Planning Application No: 3/2021/0078

We wish to make you aware of a number of strong objections that we have with regards to the proposed rear extension of Mr and Mrs Kinder at 28 Beech Drive, application number referenced above.

DRAWING TITLE / No.
PROPOSED DRAWINGS: PLANS & ELEVATIONS - 002

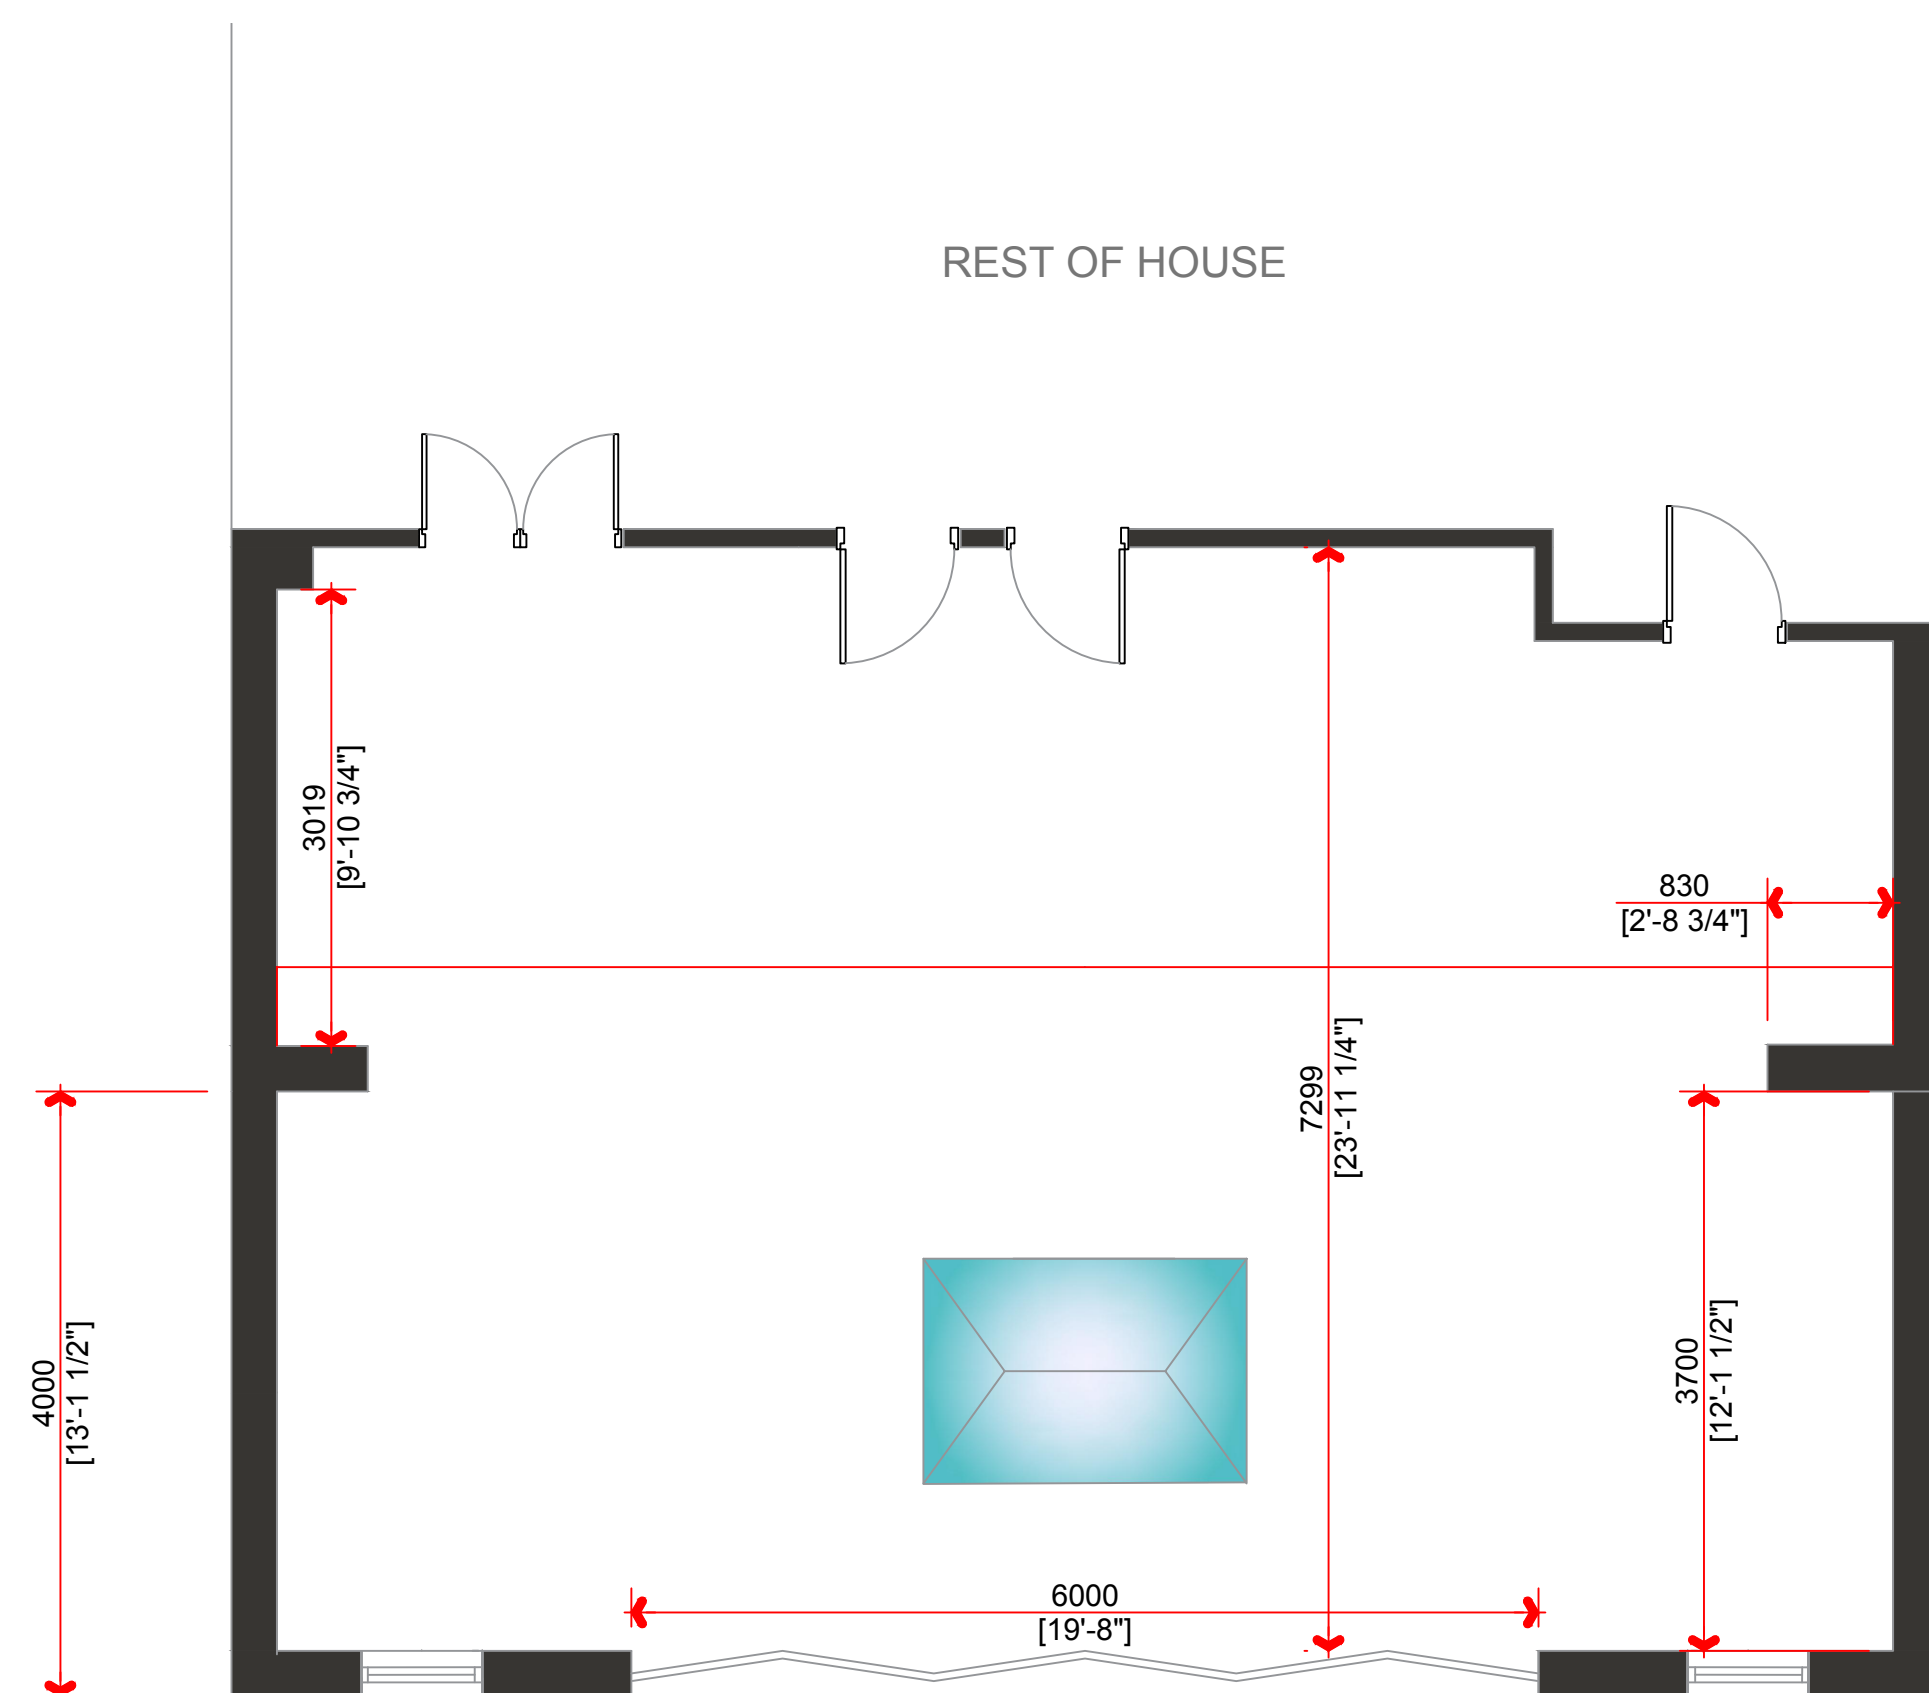
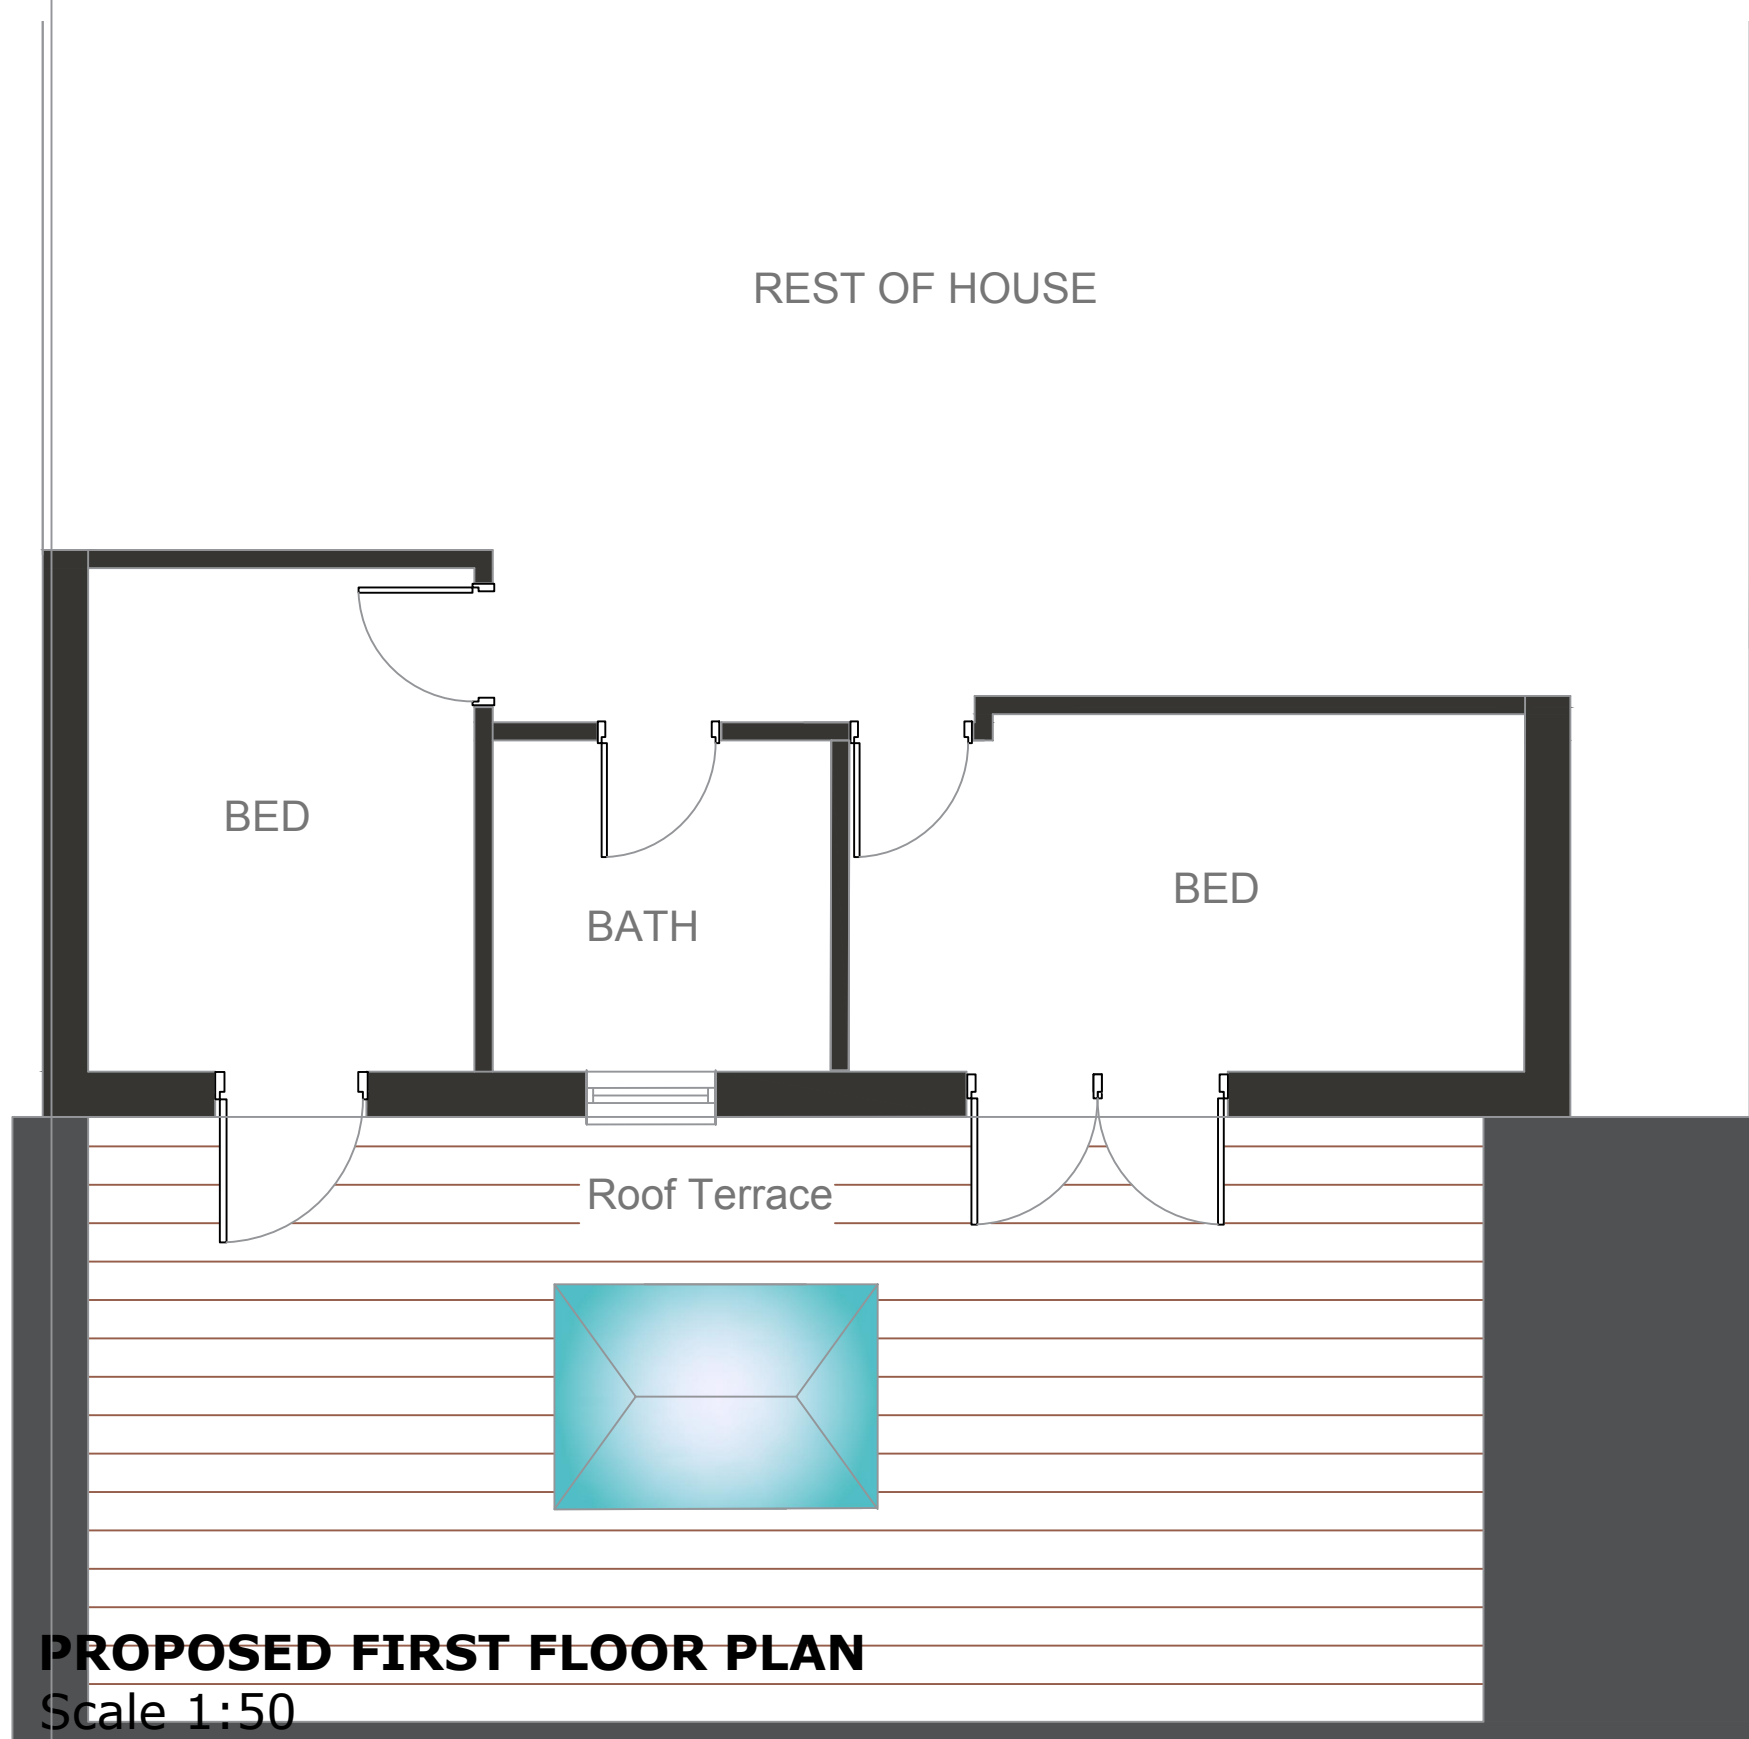
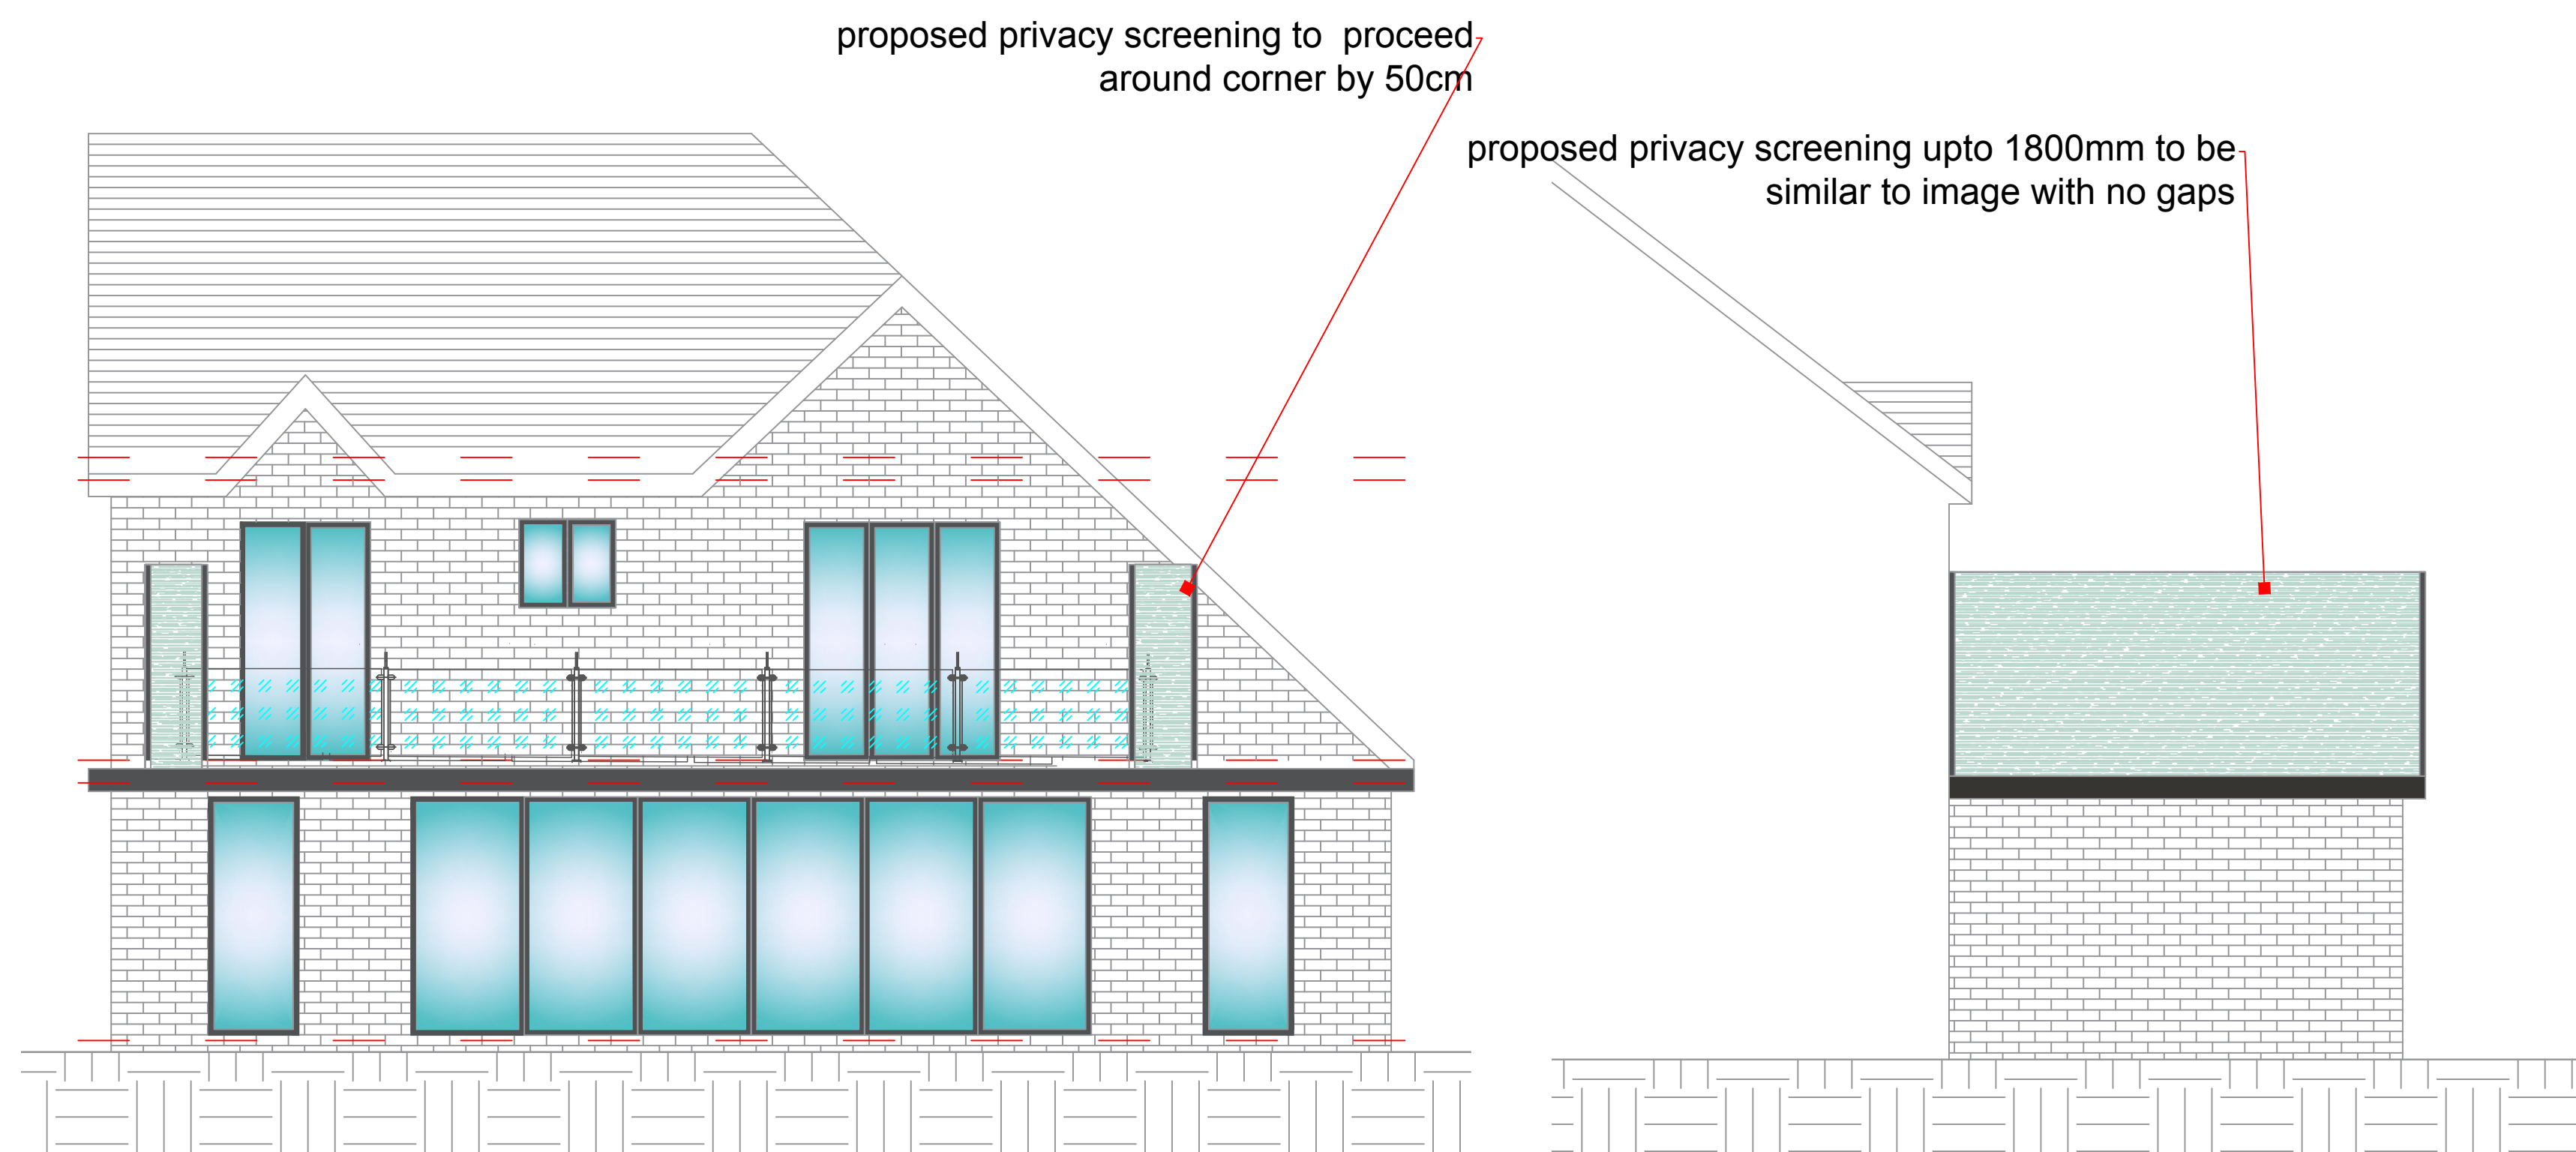
No other house on the Calderstones estate has such an extension which is planned by Mr and Mrs Kinder. The common extensions are ground floor extensions like the conservatory which is at the back of the house at 28 Beech Drive at the moment. Their planned extension is the full width of their house which is uncommon to any other extension on the estate. Also it is planned to be two floors which includes a roof terrace. This shows that the proposed extension is out-of-scale compared with existing houses in the vicinity.

The proposed extension, by reason of its size and sitting, represents an un-neighbourly form of house extension that would have an disagreeable impact on the amenity of neighbouring properties by reason of an overbearing effect.

This is not correct because to implement the planned extension there is a hedge that would need to be removed. This hedge is currently on the property of 28 Beech Drive straight next to the fence [REDACTED]

The side wall of the ground floor extension and the additional wall on the terrace (they call it "screening" on their application) [REDACTED] This is a massive loss of our existing view and adversely affects the residential attractiveness of the neighbouring owners.

Our neighbours plan of their rear extension also includes a roof terrace. This would mean a clear loss of privacy [REDACTED] At present our garden cannot be overlooked from any other neighbours while they are sitting in their garden or on their patio. With any type of outside area on the first floor the neighbour of 28 Beech Drive can overlook our garden from the front of their terrace. Additionally and also distressingly they could even look into parts of our lounge.
